## 3d Community Church

**659 Graham Rd Sanford, NC**

**9/29/25**

Harnett County

LIFE SAFETY PLAN

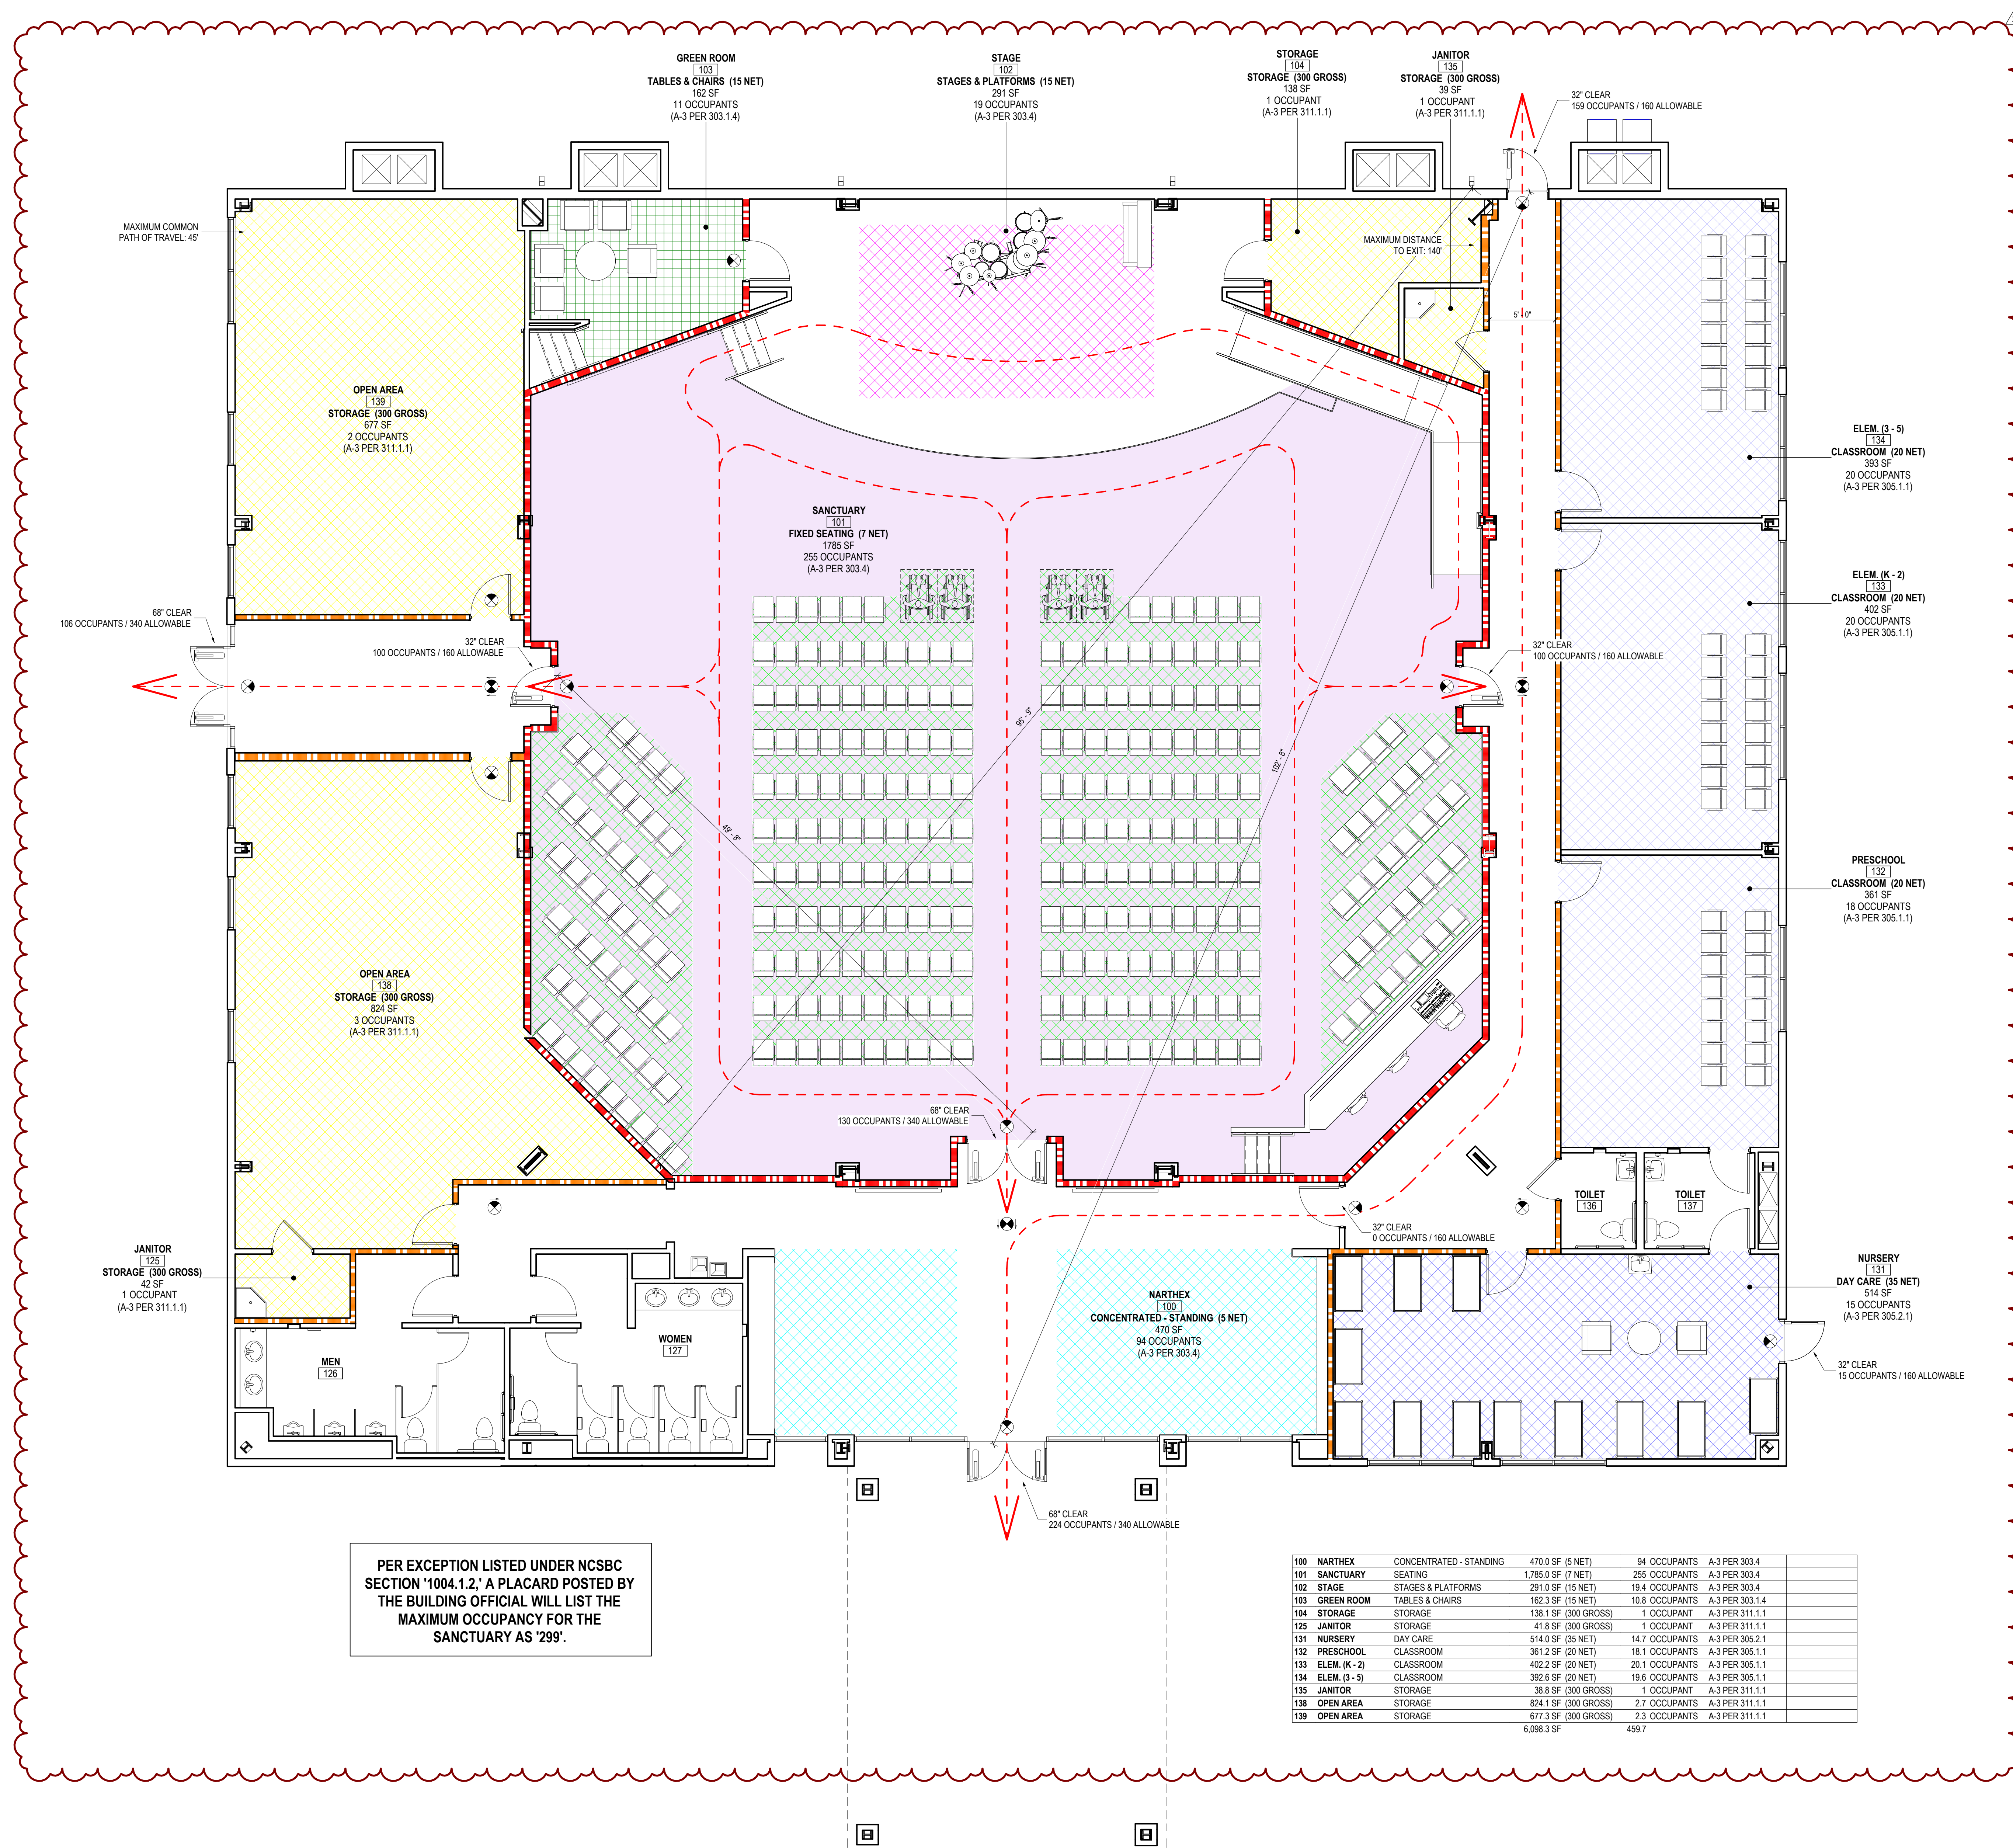
General contractor shall extend the one and two-hour fire rated wall framing and sheetrock tight to the roof insulation/tarp system. Apply fire caulk at the top of sheetrock. Allow deflection at the roof structure. — Follow UL Designs UL419 and V449.

Provide top of wall condition at rated walls indicated in red and orange below.

Hilti Detail CJ-D-0008 is good for 1, 2 and 3 layers of Sheetrock as well.
